Our reference: P-376868-Y2C0
Contact: Kathryn Saunders, Principal Planner
Telephone: (02) 4732 8567

20 October 2022

SSD-10272349 – Response to Submissions for Yiribana Logistic Estate

Thank you for providing Penrith City Council with the opportunity to comment on the Response to Submissions (**RtS**) in relation to the abovementioned State Significant Development (**SSD**) Application. Council's advice on the RtS is provided below with recommended standard engineering conditions at **Appendix A**.

STORMWATER DRAINAGE MASTER PLAN
SCALE 1:1000

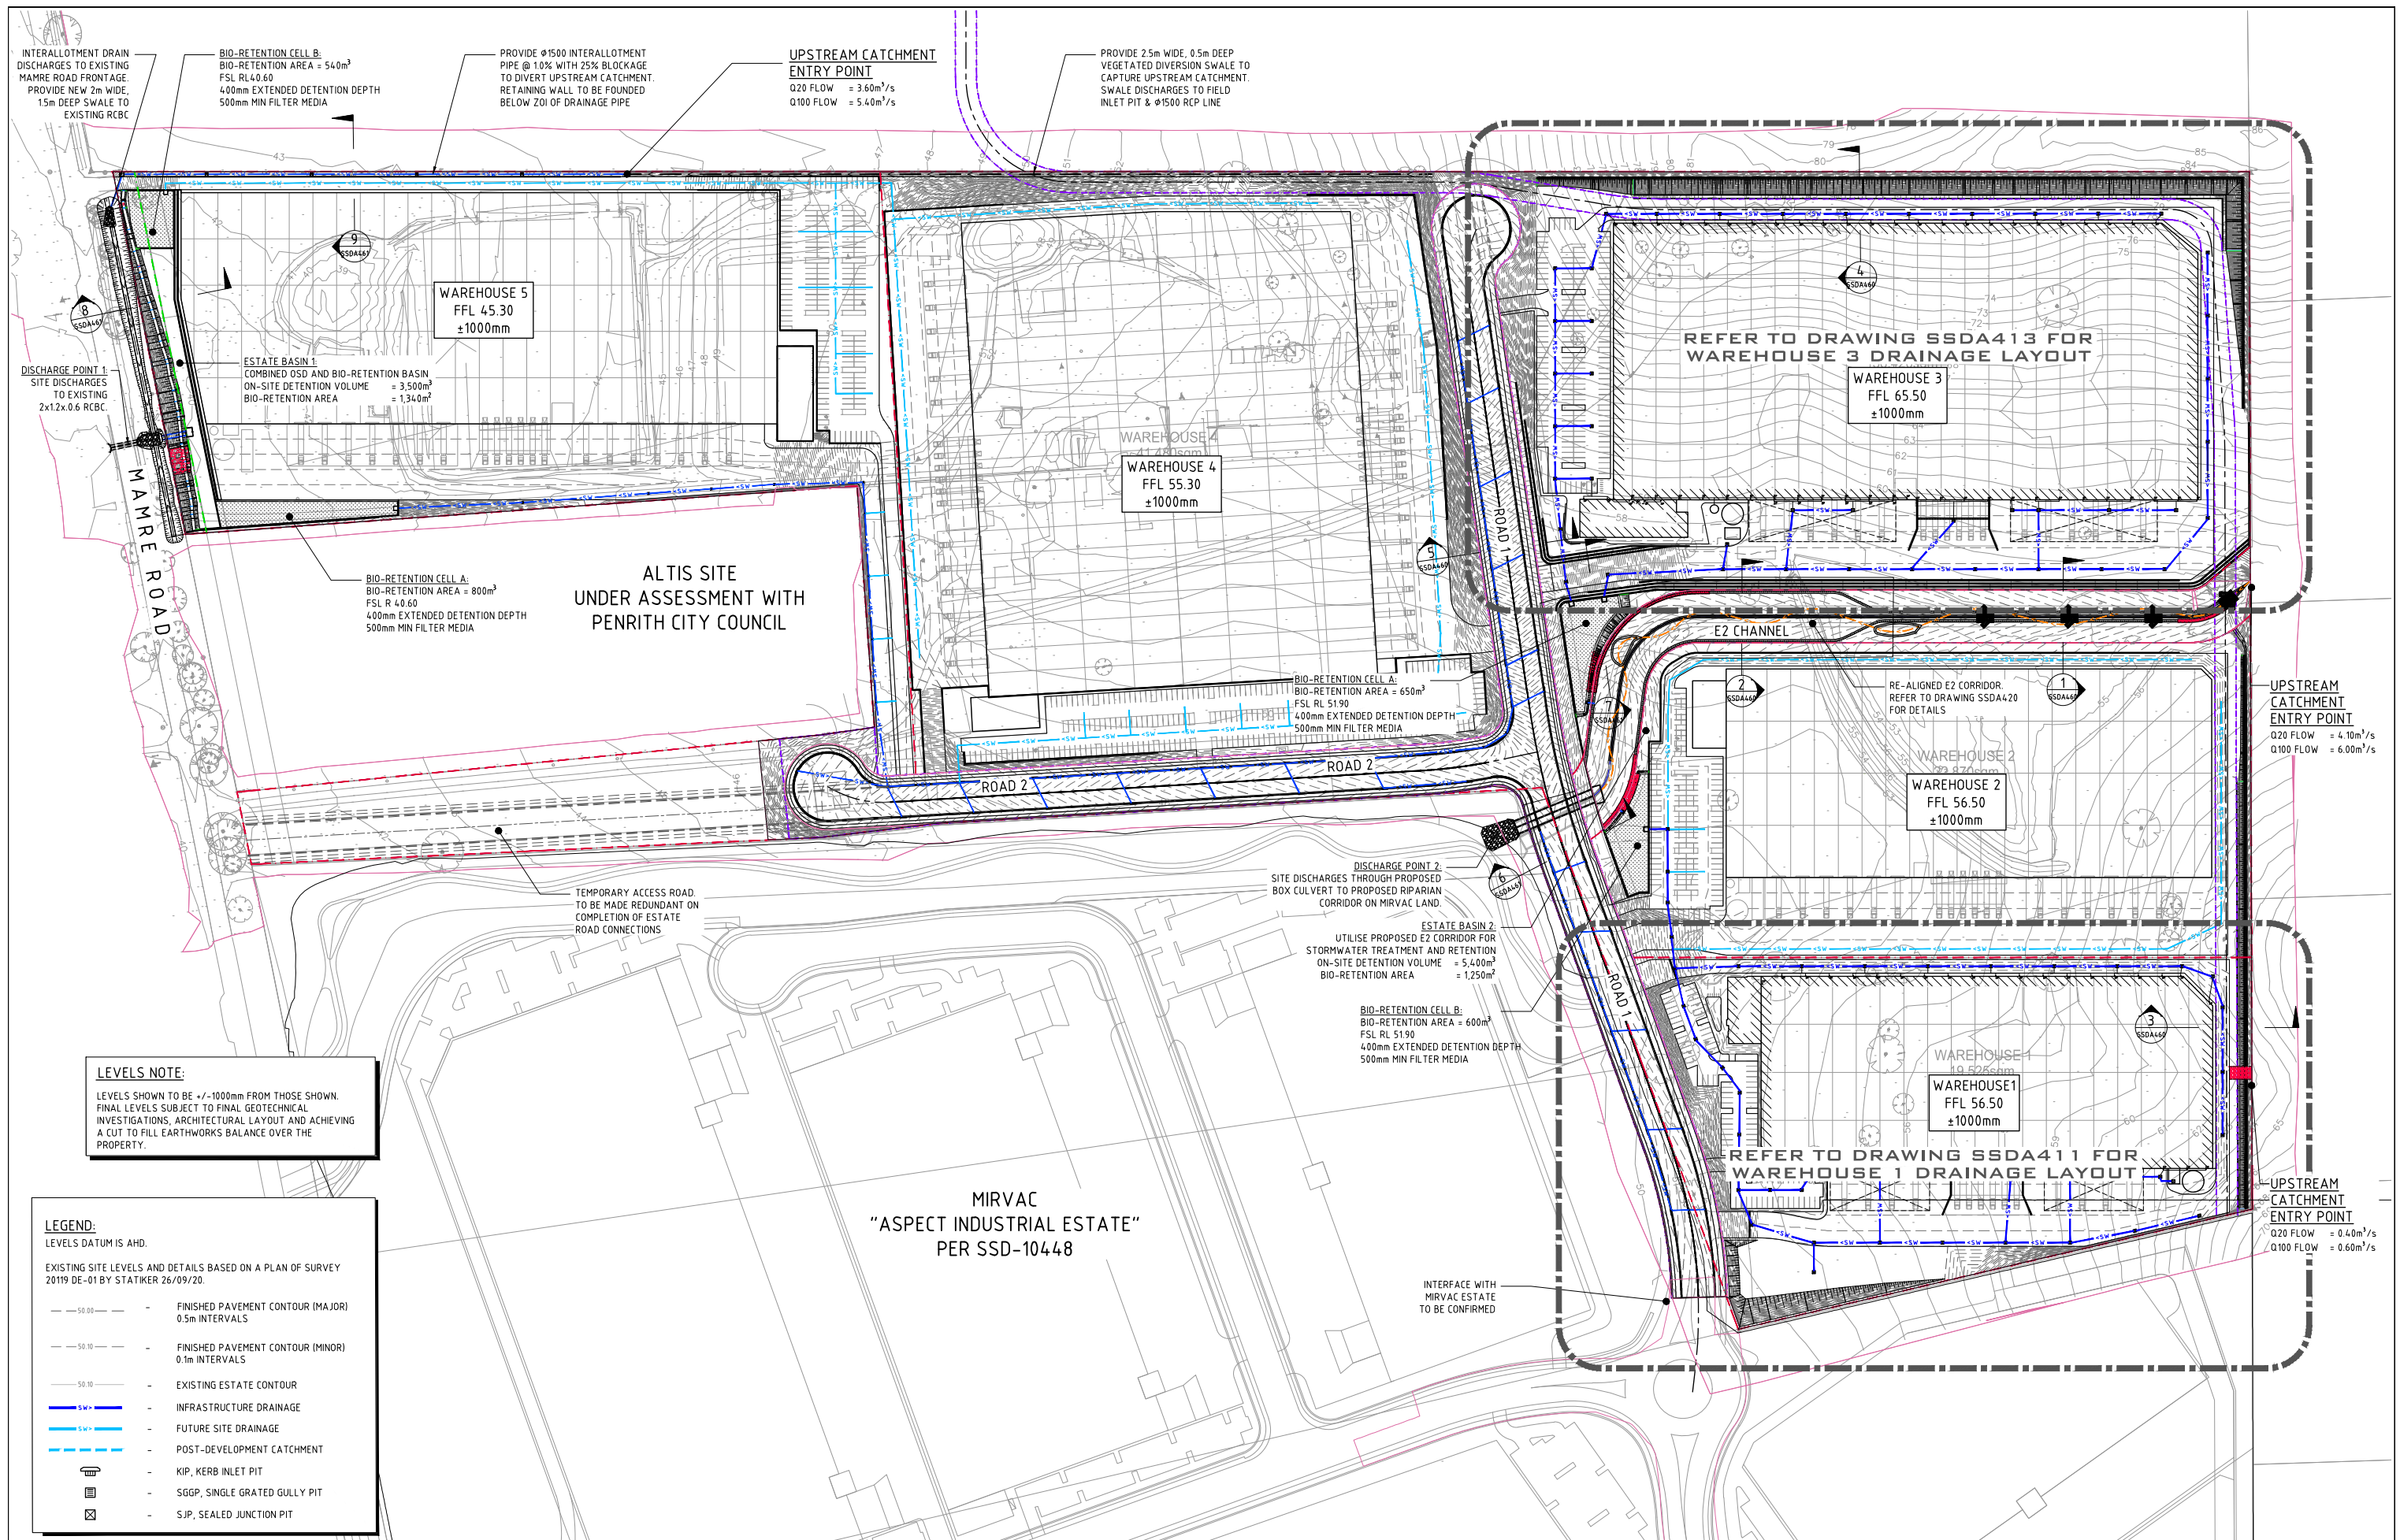
Civil plan no. SSDA432 indicates that Estate Basin 2, which is a combined OSD and bio basin is located in the corridor. DPE is to ensure that the corridor is for 'riparian' purposes and not OSD and trunk drainage.

Bio Basin 1B and Estate Basin 1 are located within the landscape setback of Mamre Road, this aspect is not supported as discussed under the Planning section above.

Access for maintenance purposes to all stormwater basins and the riparian corridor have not been provided on the plans.

E2 CORRIDOR ALIGNMENT PLAN
SCALE 1:500

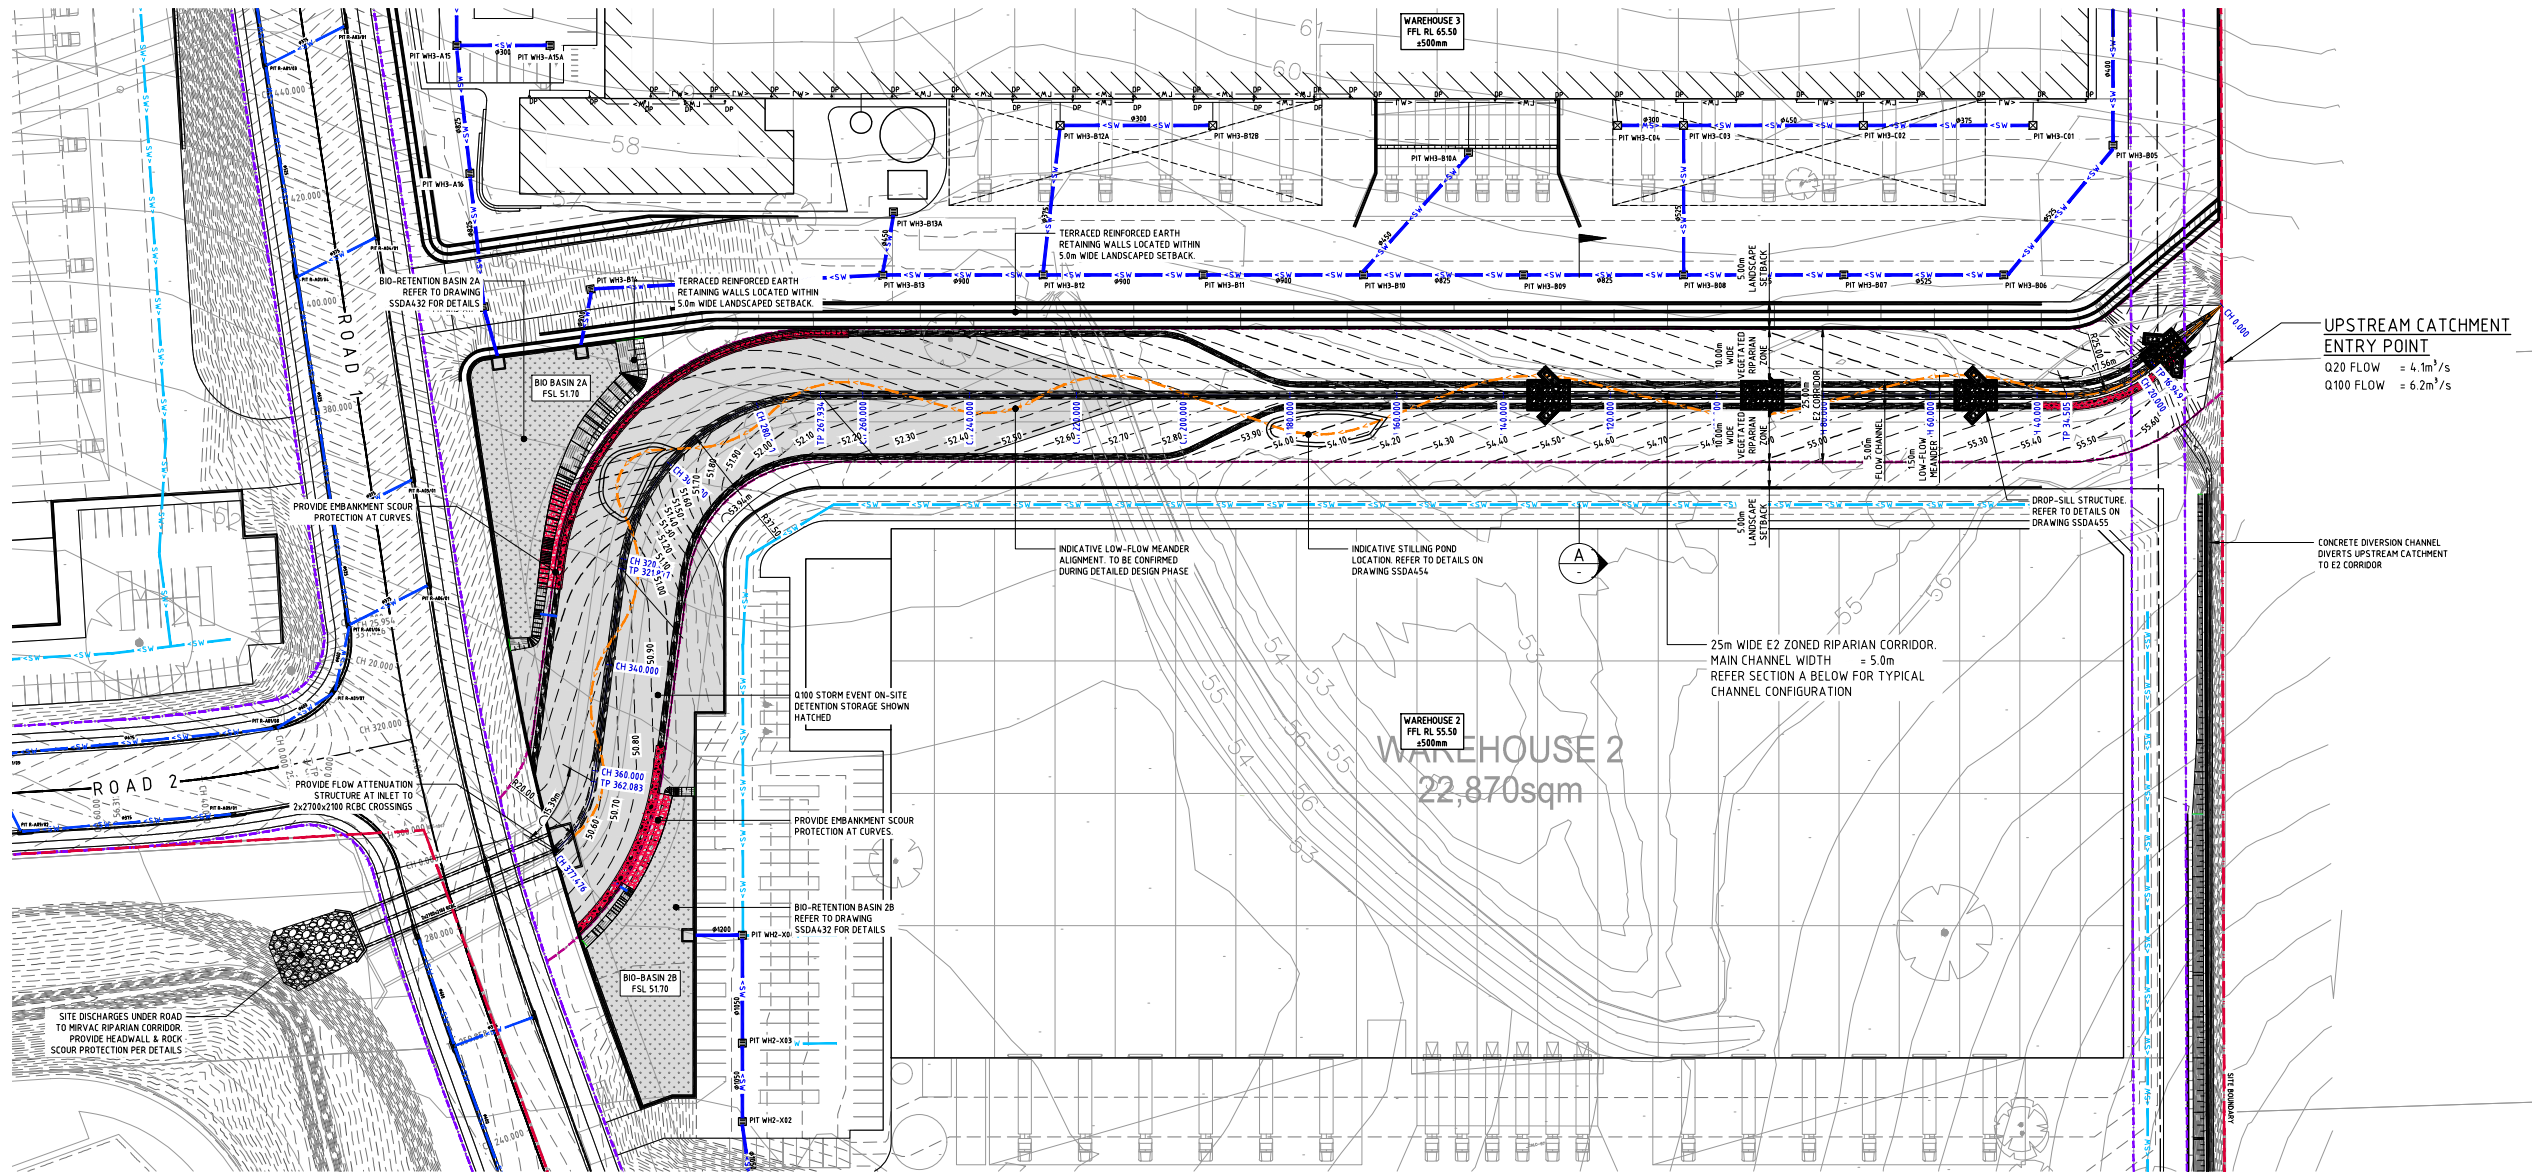
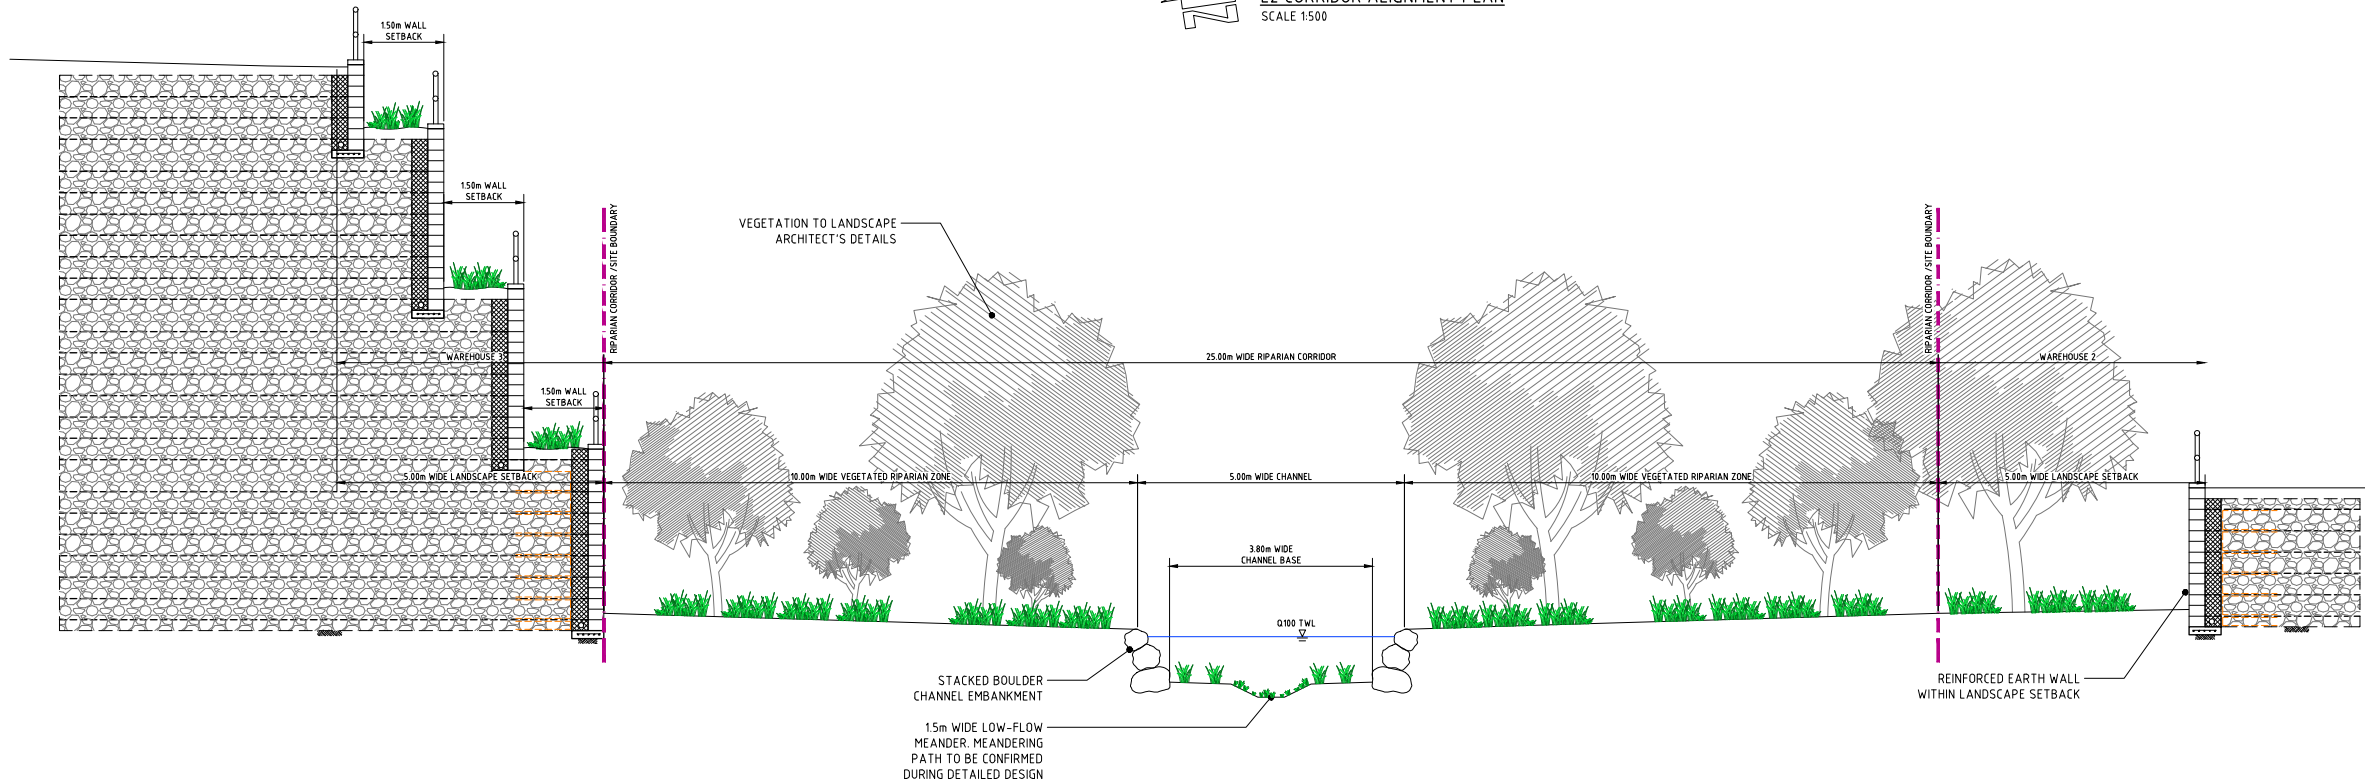
Plans are notated with '*Proposed E2 Riparian Zone*'. It is unclear what this means.

'Riparian' is understood to mean land which might have biodiversity values attached to wetlands or adjacent to creeks and the like. The proposed landscaped corridor is not considered to deliver 'riparian' land. The corridor will be fenced and is severed by a road (with box culverts) at the south-

western end and is not connected to bushland or a catchment to the east. Plans for the eastern end of the corridor are not provided in the SSDA package.

The applicant is to clarify if the statement '*Proposed E2 Riparian Zone*' relies on a re-zoning from IN1 General Industrial to C2 Environmental Conservation under SEPP (Industry and Employment) 2021 and is to fully describe the process proposed to be undertaken to achieve such.

Civil plans indicate that 'clean water' will be diverted from upstream into the corridor, however this is likely to be temporary given the proposed redevelopment of the upstream land and the extent of earthworks envisaged.

If the corridor does not have a catchment, it will be a dry channel and not 'riparian' land. No details of the catchment requirements are provided in the VMP. The VMP does not advise as to the minimum catchment needs of the corridor to achieve 'riparian' status.

DPE is to ensure that the corridor is provided with connectivity to an identified long-term catchment.

LONGITUDINAL SECTION - GPT E2 CHANNEL

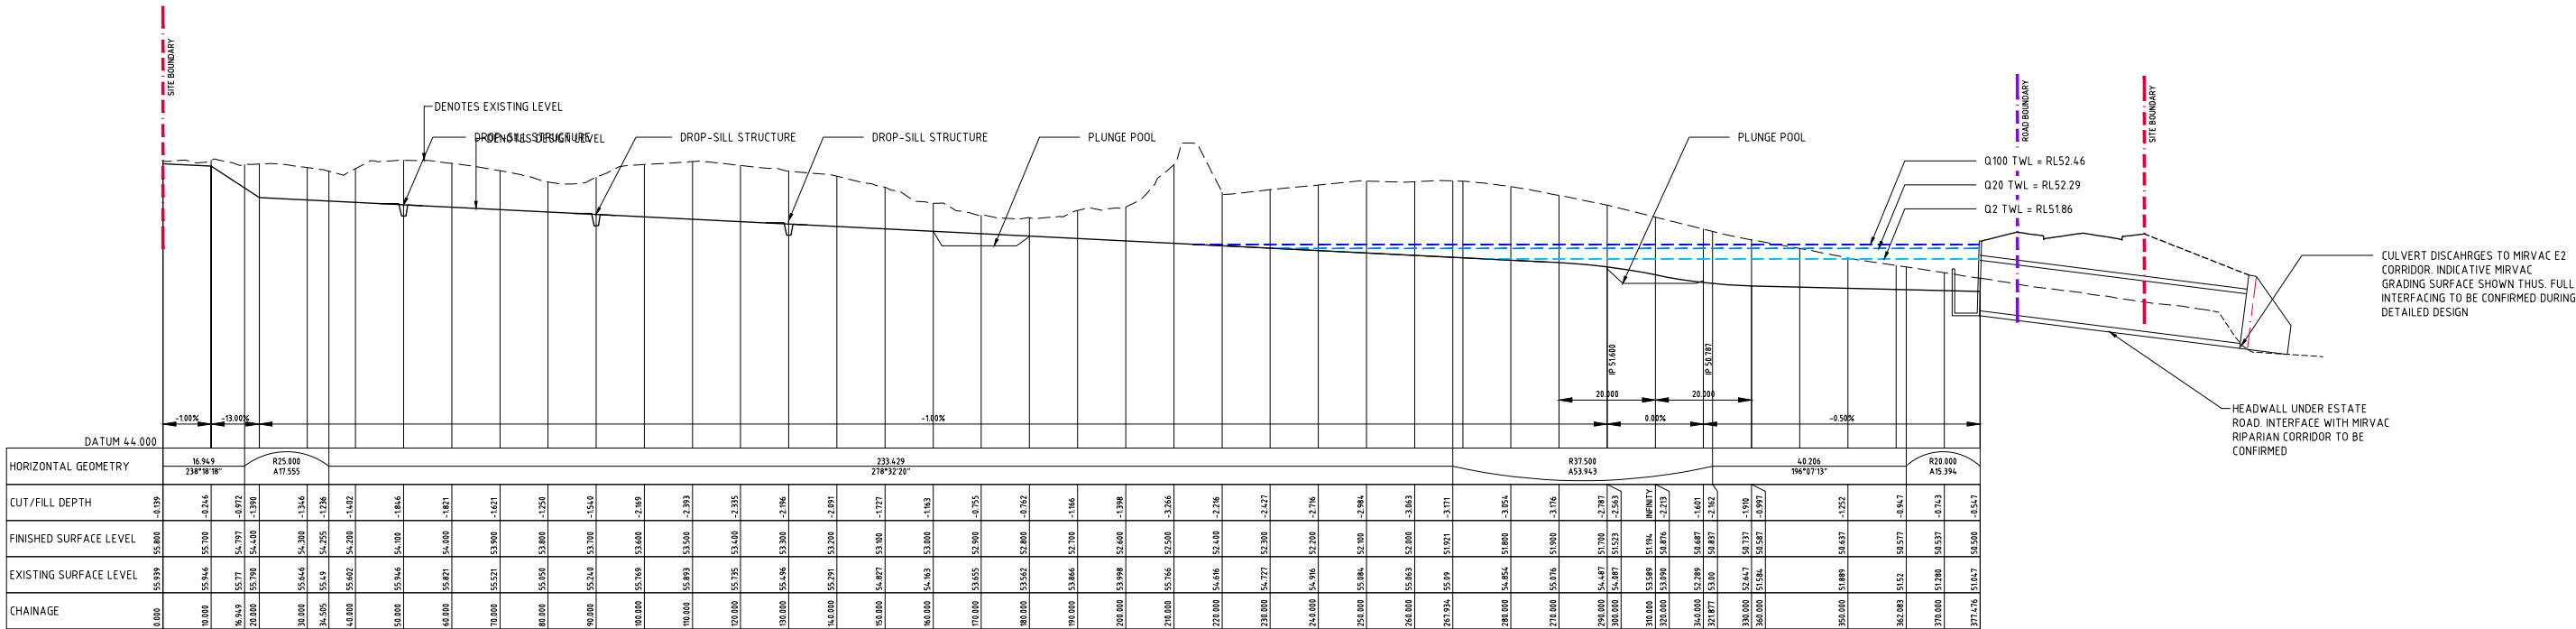
The Submissions Report states that the landscaped corridor is 35m wide and the section at page 18 confirms that the corridor is to be 30m wide at the base exclusive of 2 x 5m wide landscaped setback areas each side, which are proposed to be fenced off from the central corridor. The VMP states that the corridor is 40m wide. The Revised Civil Engineering and WCM Strategy (p.33) states that the corridor will be 50m wide. DPE is to clarify what the final layout of the corridor is.

With respect to the riparian corridors, the proposed configuration including the proposed retaining walls does not appear to be consistent with the intent of the MRDCP. It's suggested the design of the riparian corridor should be reconsidered to ensure it meets the objectives of Sections 2.3 and 2.4 (e.g., Figure 3) of the MRP DCP. Further reference is made to Control 17 in (Section 2.4 if the MRPDGP) which states *High vertical walls and steep batters shall be avoided. Batters shall be vegetated with a maximum batter slope 1V:4H. Where unavoidable, retaining walls shall not exceed 2.0m in cumulative height.*
